> Prior to submitting the TCL for approval please address comments below. Please submit pages A-1.0, A-1 & A-3.

> Subject: Re: 113 Eubank Blvd

1 NEW RAMP DETAIL
A-1 SCALE: 1"= 1'-0"

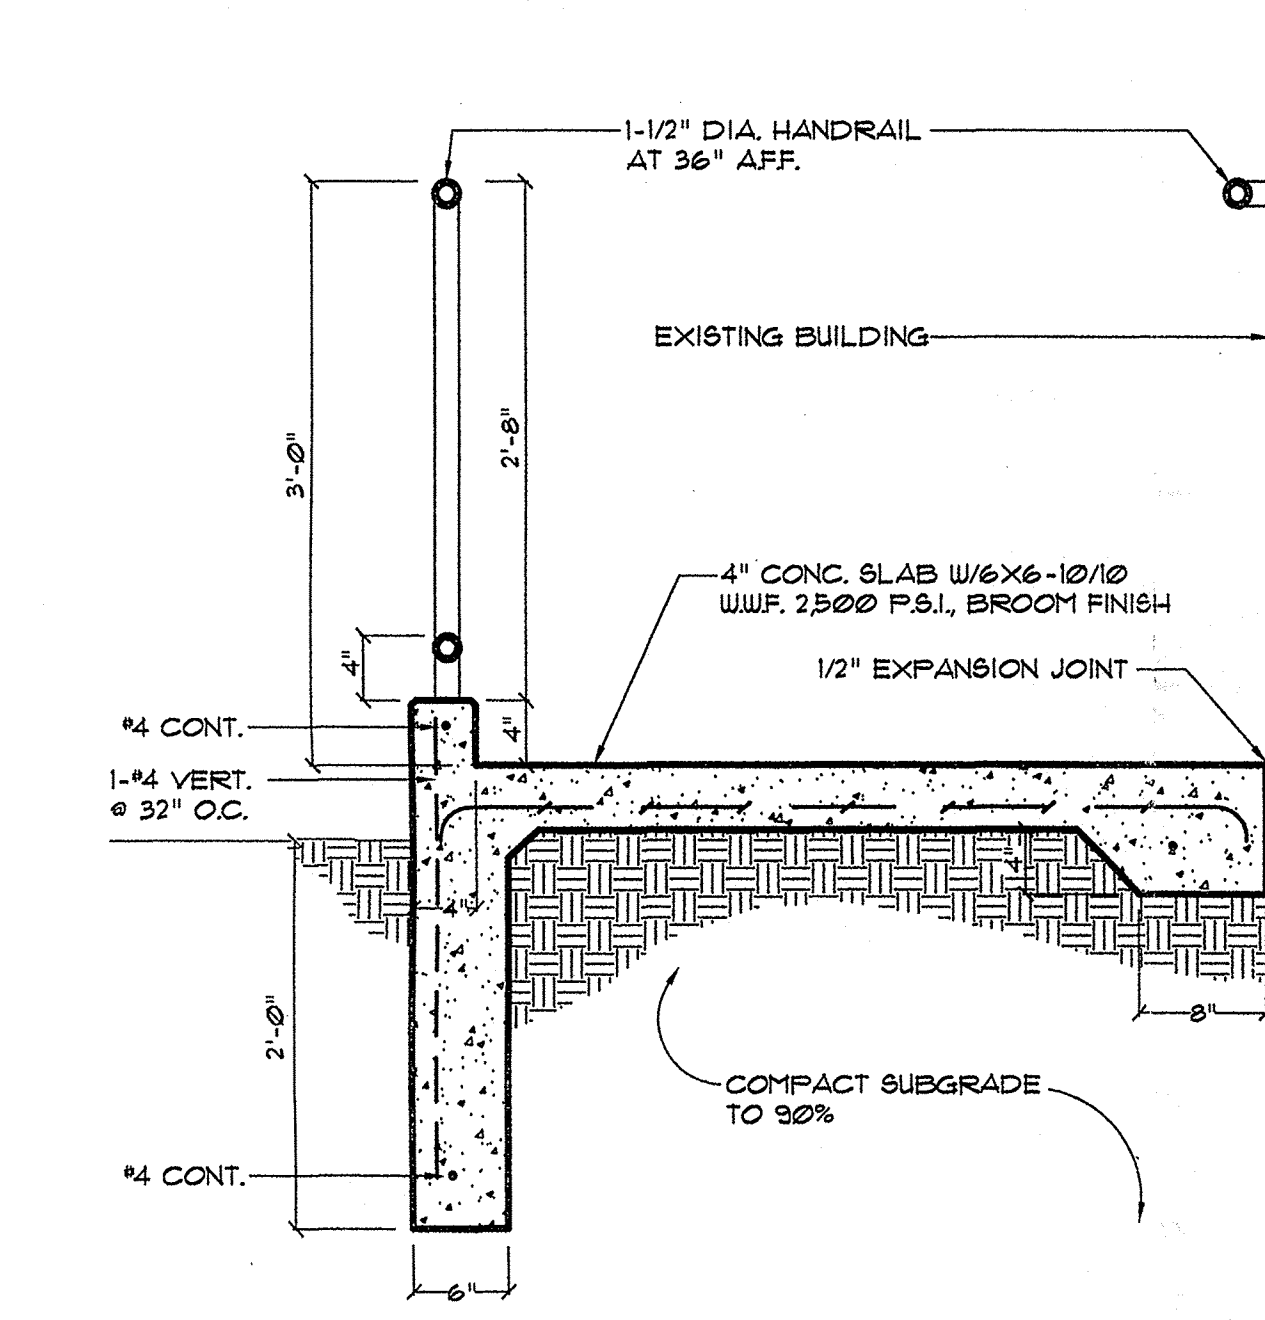
> 6. Please add note on new concrete ramp. Cross slope not to exceed 2.0%

A-1

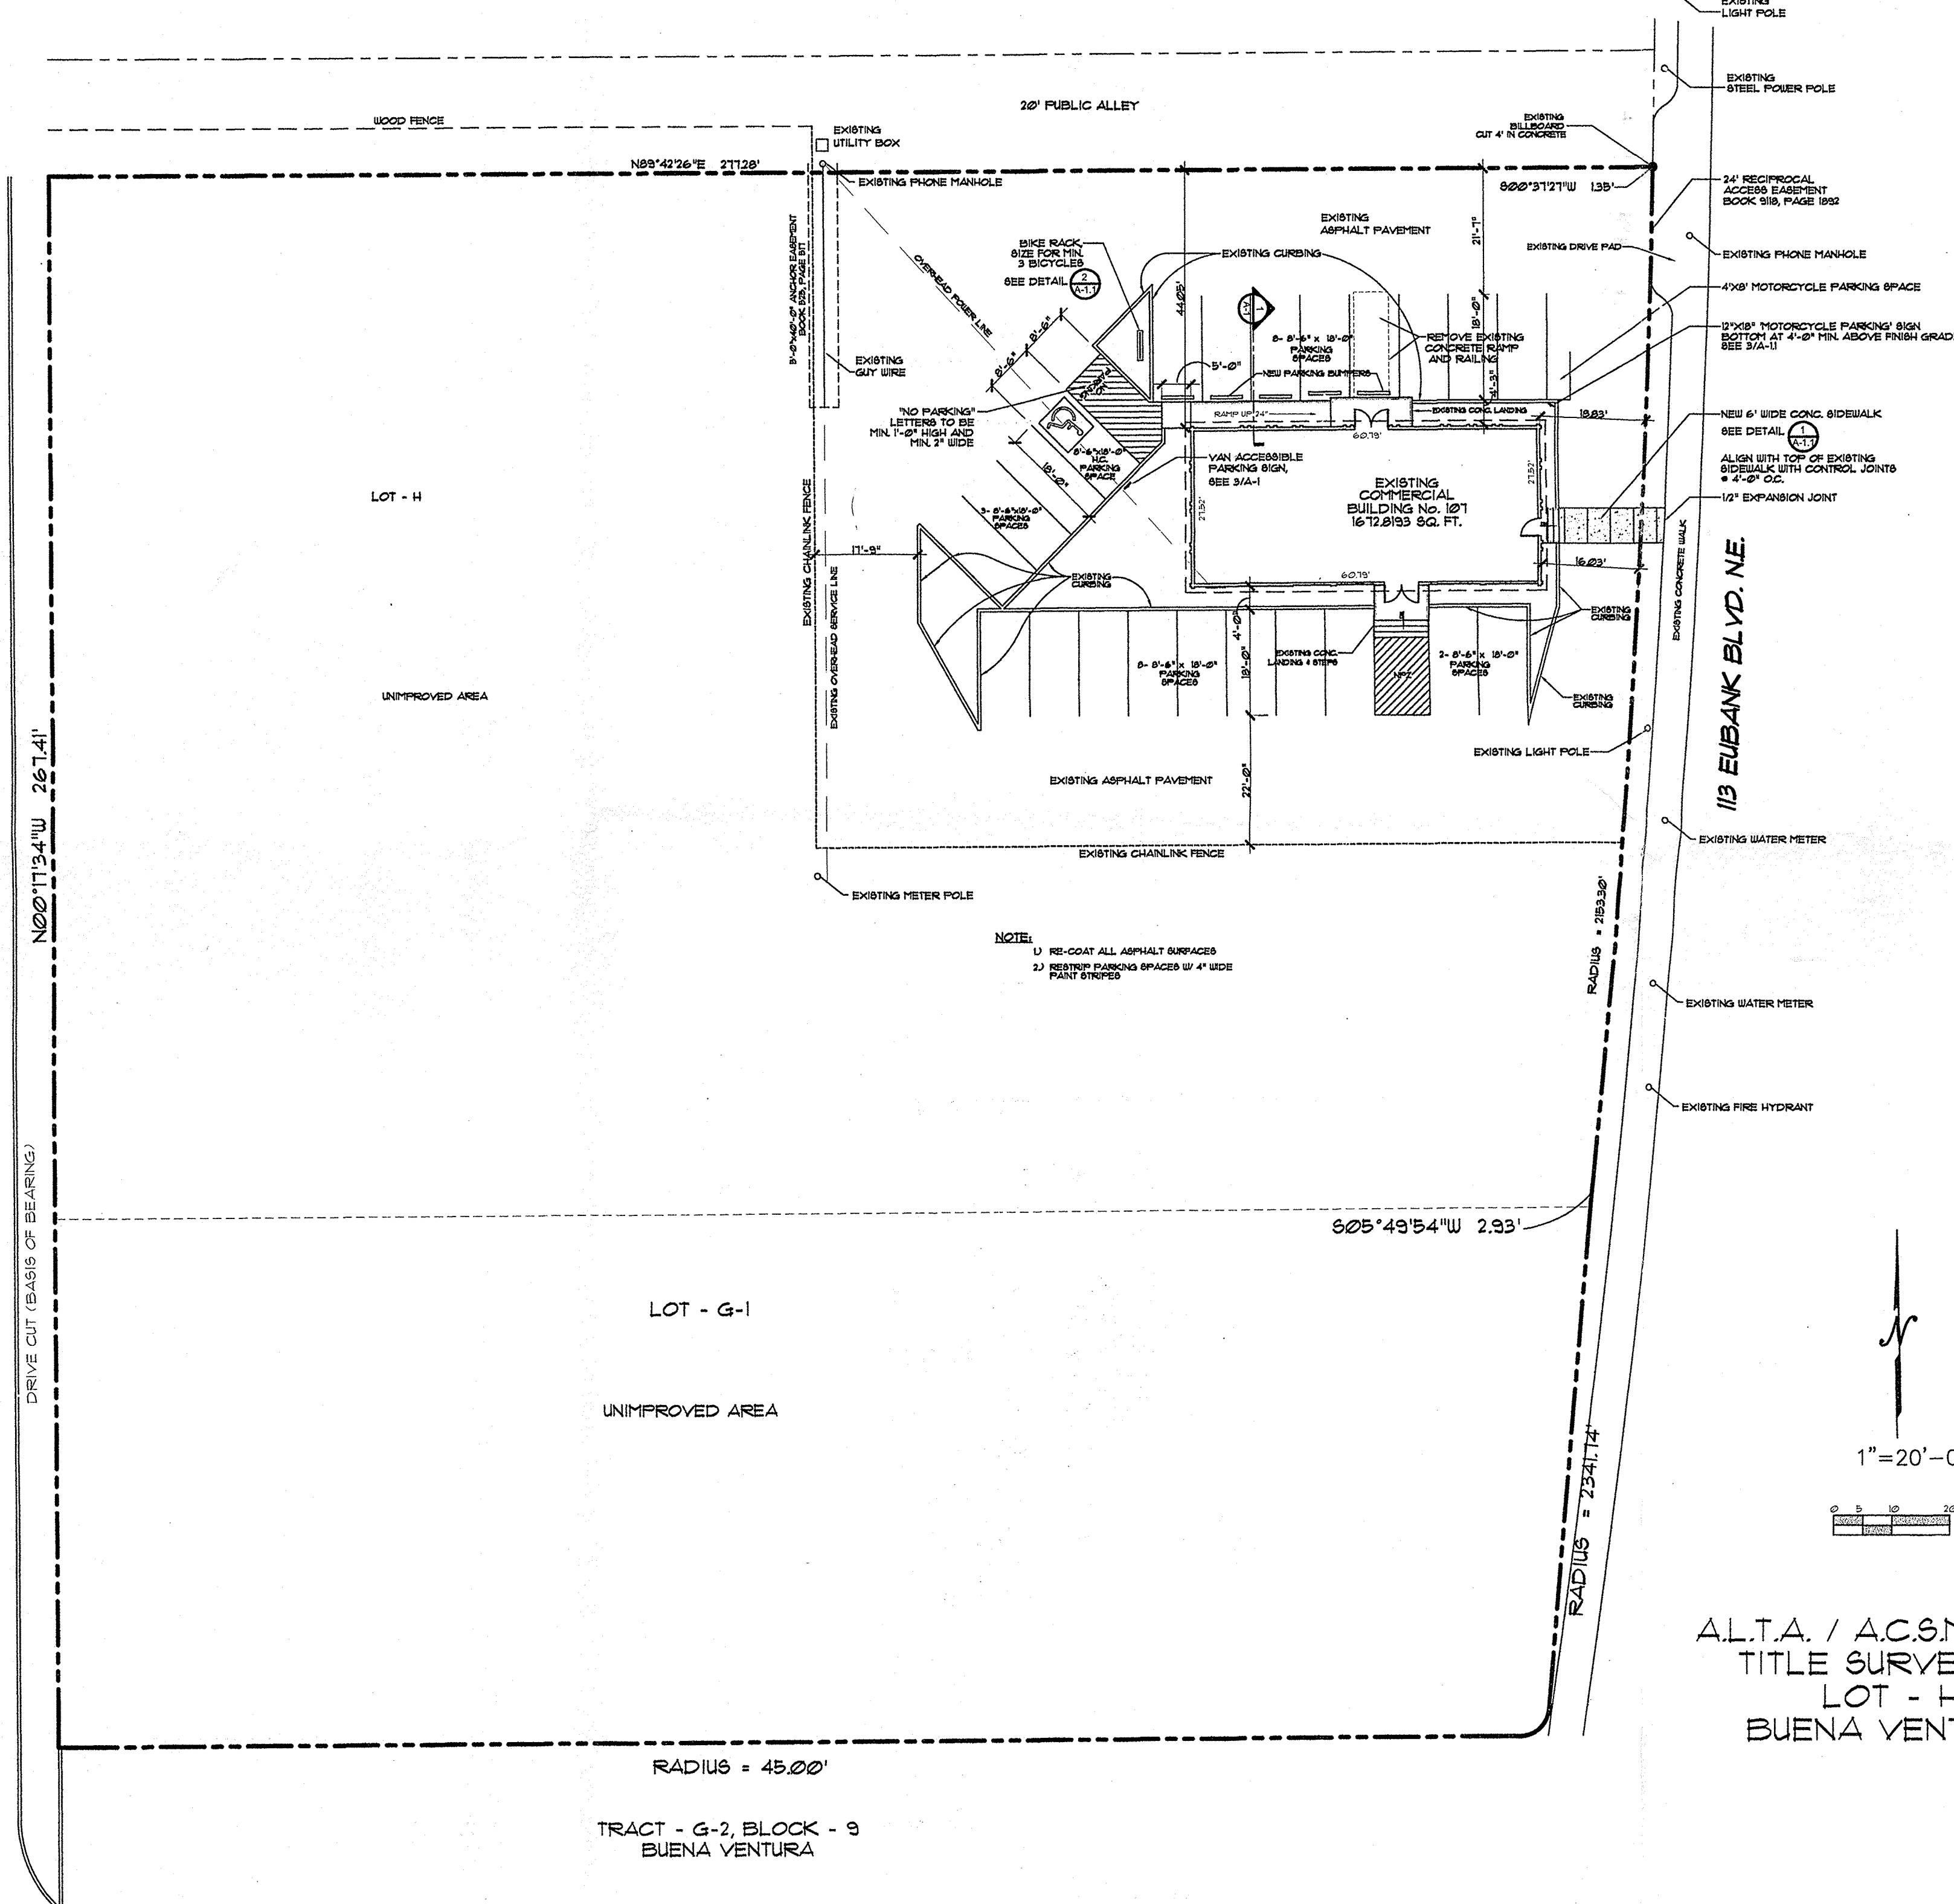
> 1. Please identify all existing buildings, doors, structures, sidewalks, curbs, drive pads, wall and anything that influences the parking and circulation on the site.

> 2. Show all drive aisle widths.

2 VAN ACCESSIBLE SIGN
A-1 SCALE: 3/4"= 1'-0"

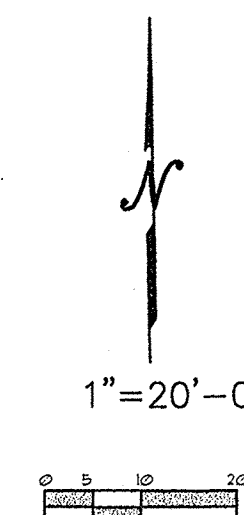
> 3. The ADA accessible parking sign must have the required language per 66-7-352.4C NMSA 1978 "Violators Are Subject to a Fine and/or Towing." Please call out detail and location of HC signs.

ENLARGED SITE PLAN
SCALE: 1"= 10'-0"

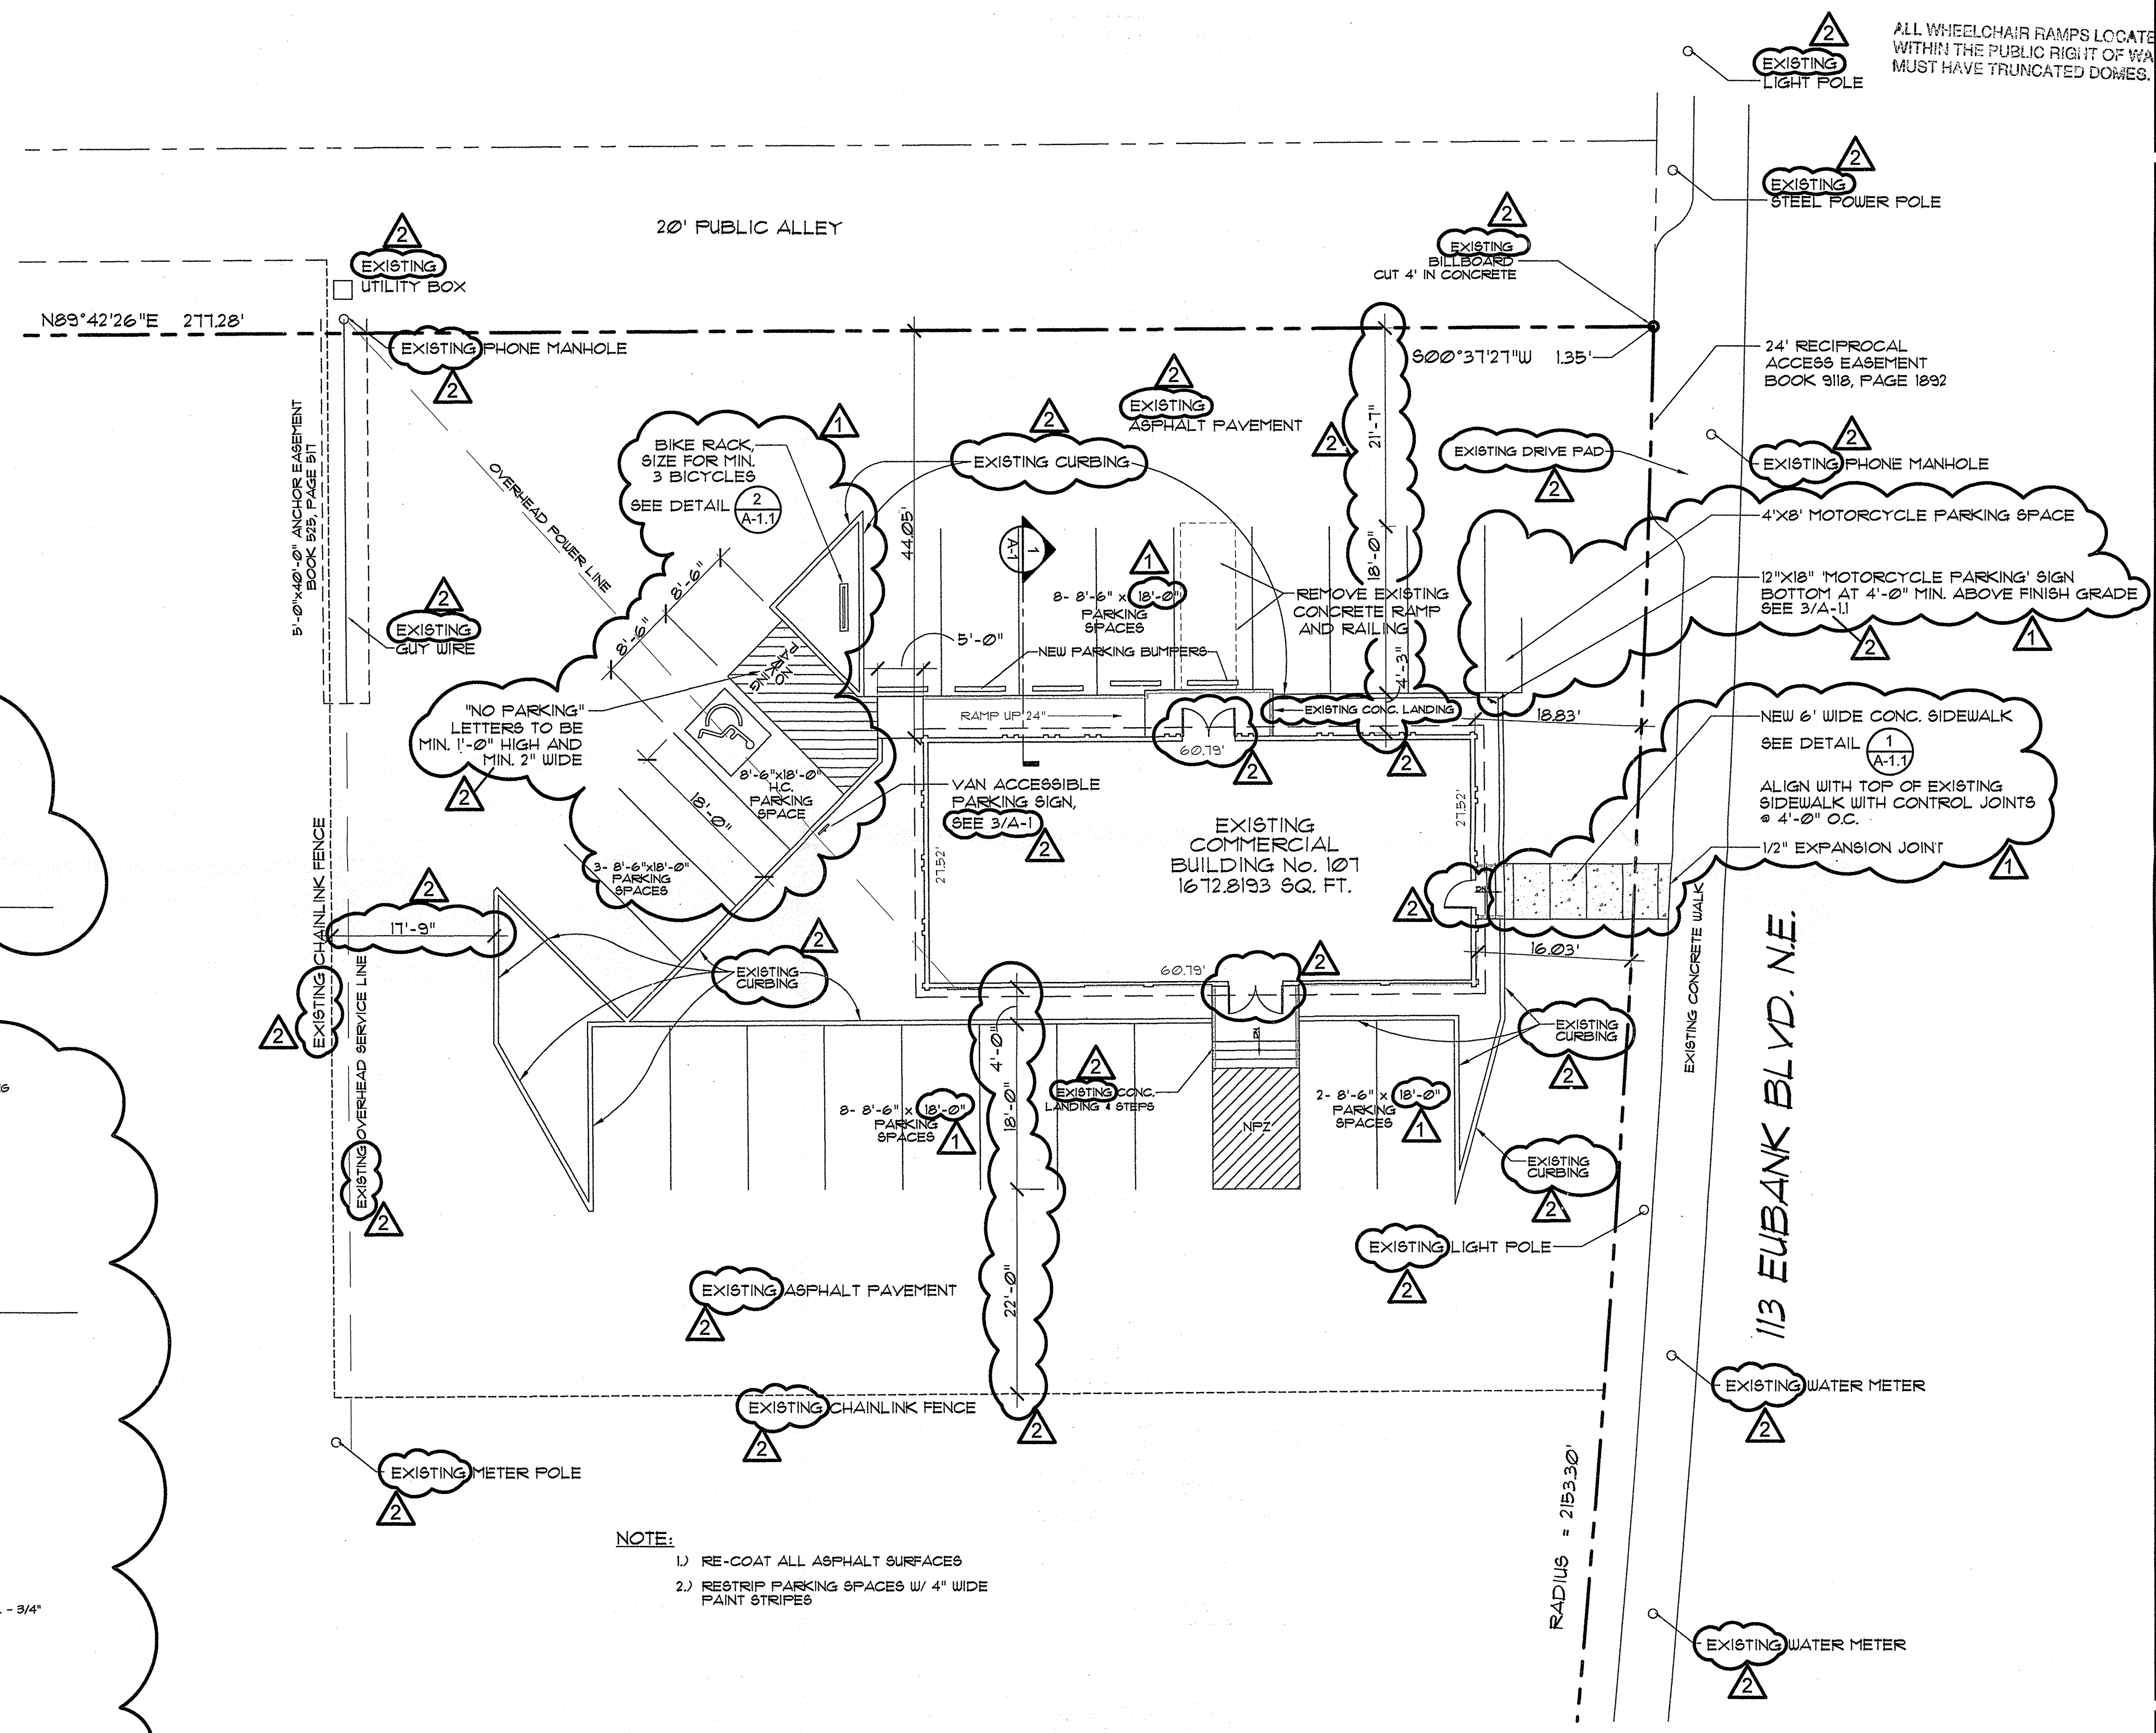
> 4. The ADA access aisles shall have the words "NO PARKING" in capital letters, each of which shall be at least one foot high and at least two inches wide, placed at the rear of the parking space so as to be close to where an adjacent vehicle's rear tire would be placed. (66-1-4.1.B NMSA 1978). Please add note.

3 MOTORCYCLE PARKING SIGN
A-1.1 SCALE: 3/4"= 1'-0"

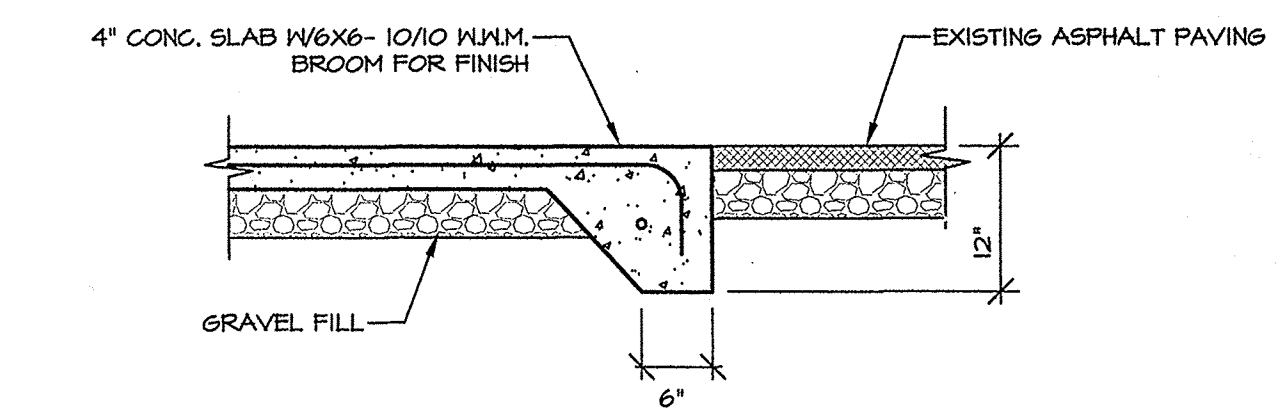
> 5. Please add motorcycle sign detail.
